Kirklees Council
Planning and Development Service
PO Box 1720
Huddersfield
HD1 9EL

Date: 06-Oct-2026
Our Ref: 2026/91545

**Application for Approval of Details Reserved by Condition
Town and Country Planning Act 1990
Planning (Listed Buildings and Conservation Areas) Act 1990**

**Discharge of details reserved by conditions 3 (noise report), 4 (acoustic details), 6 (bin store) on previous permission 2024/92848 for alterations to convert first floor to 2 dwellings; sub-division of one ground floor retail unit to two retail units (use class Ea); installation of new shop fronts to south and east elevations and construction of external staircase to northern elevation including associated works
Marsh Carpets, 82-84, Westbourne Road, Marsh, Huddersfield, HD1 4LF
Application Number: 2026/91545**

Drawing
Bins Store Details

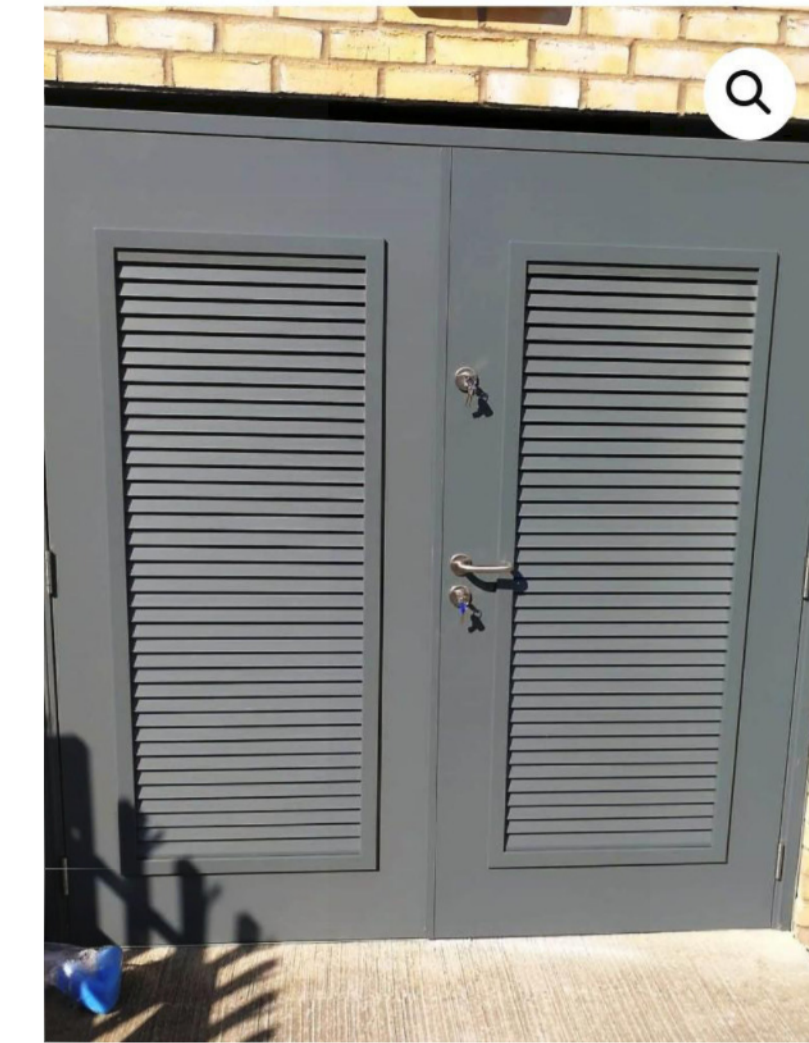
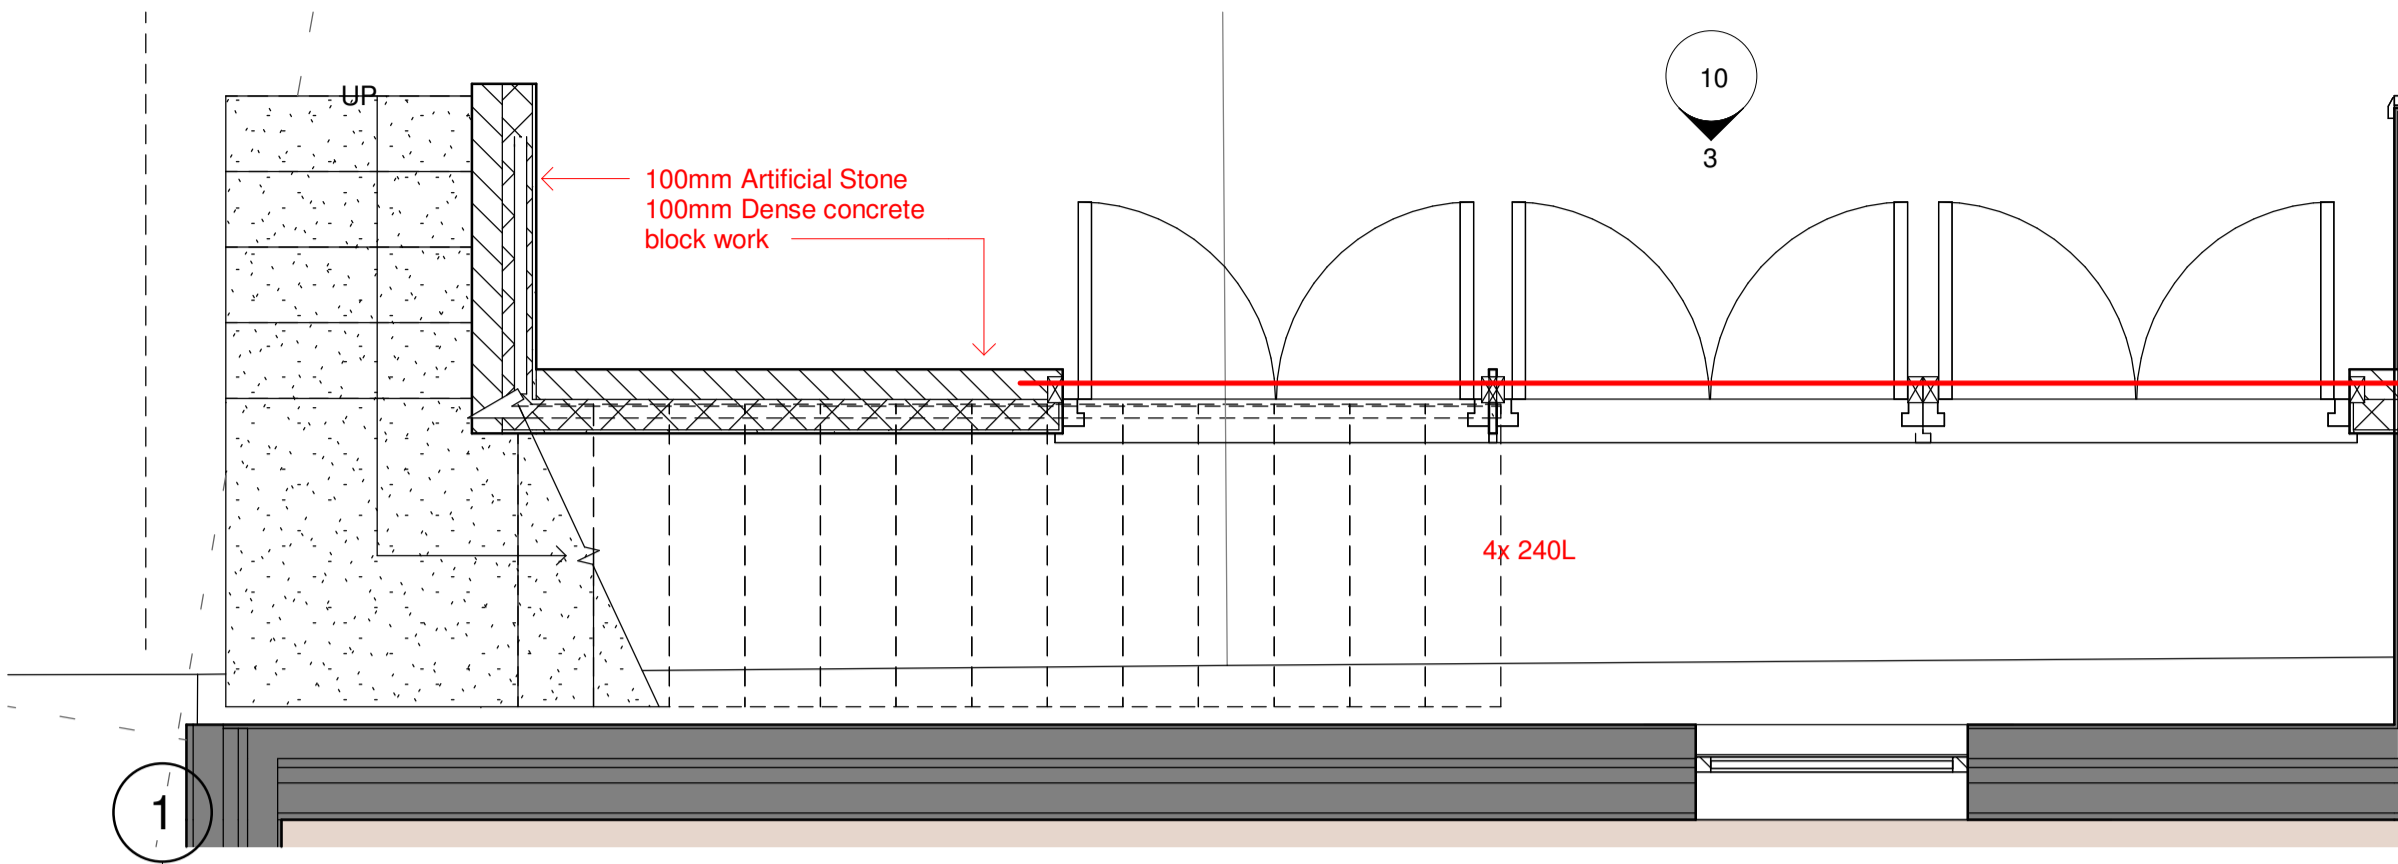
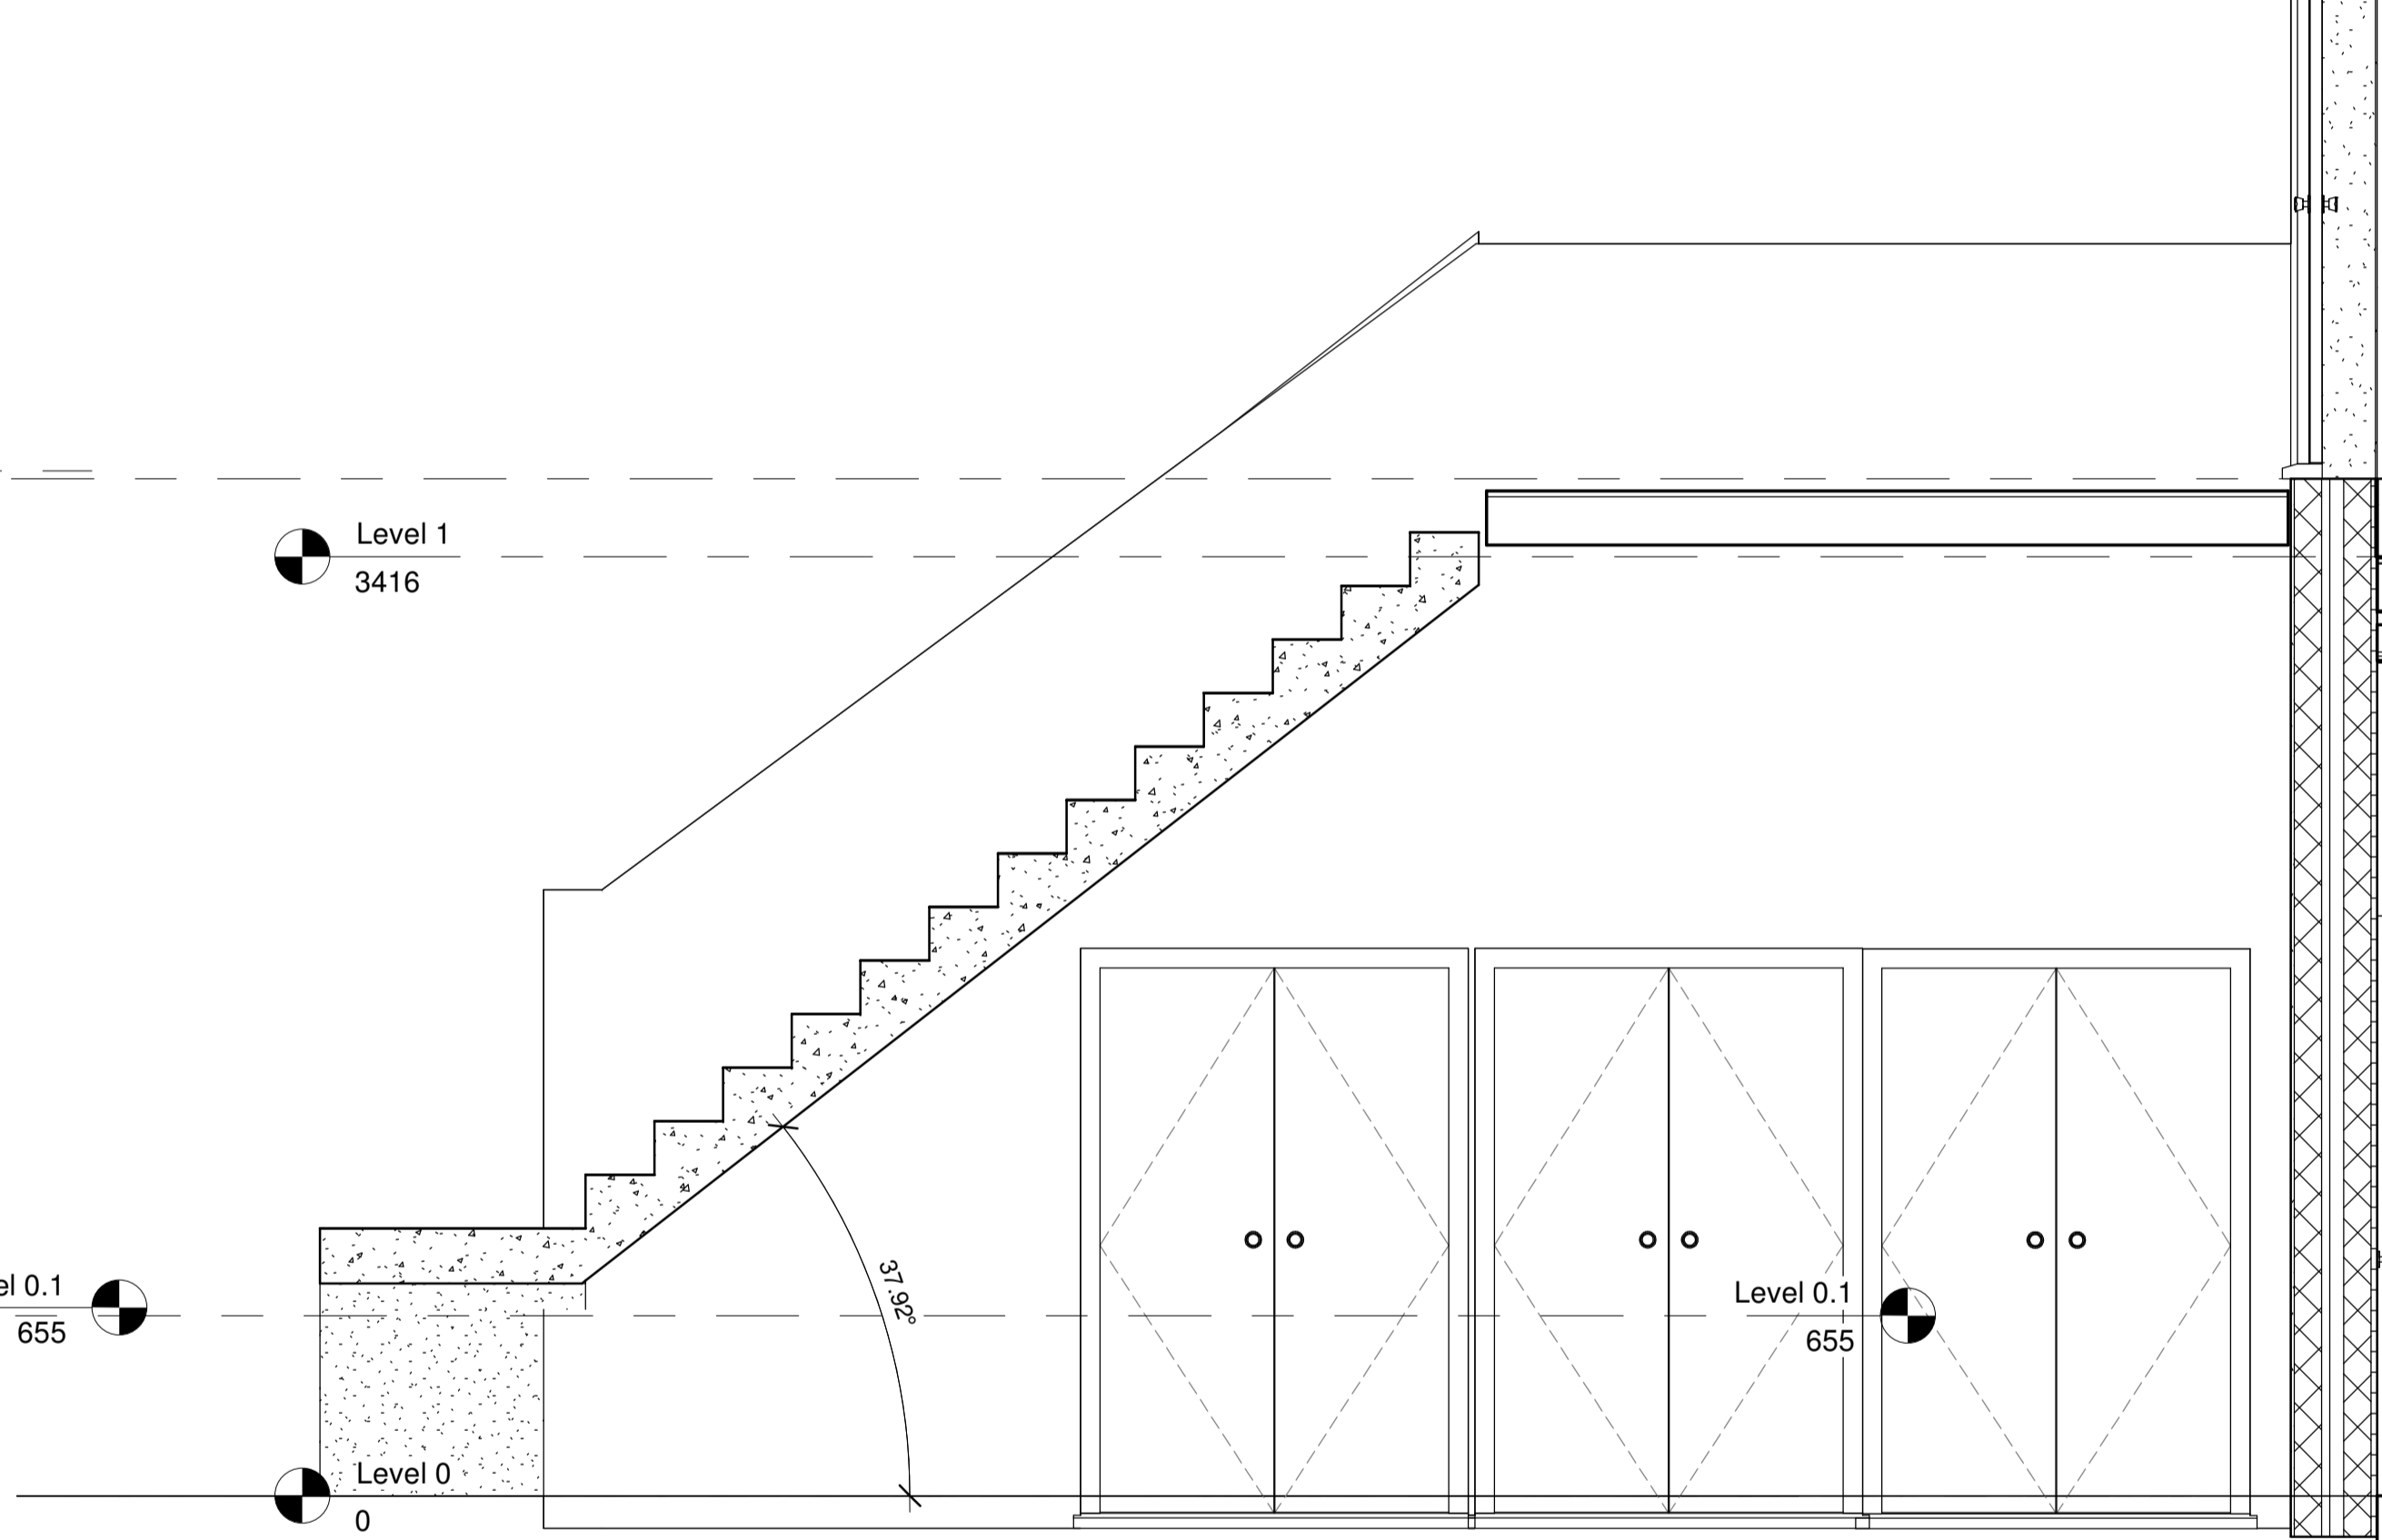
With regards to outstanding matters pertaining to bin collection and storage, the agent has submitted "Bins Store Details" referenced, drawing No. UD-556 and further commentary in an email with plan received on the 9th September 2026. The details provided are considered acceptable for the discharge of Condition 6 but must be provided and retained in perpetuity.

For the purpose of this application Condition 6 can be discharged.
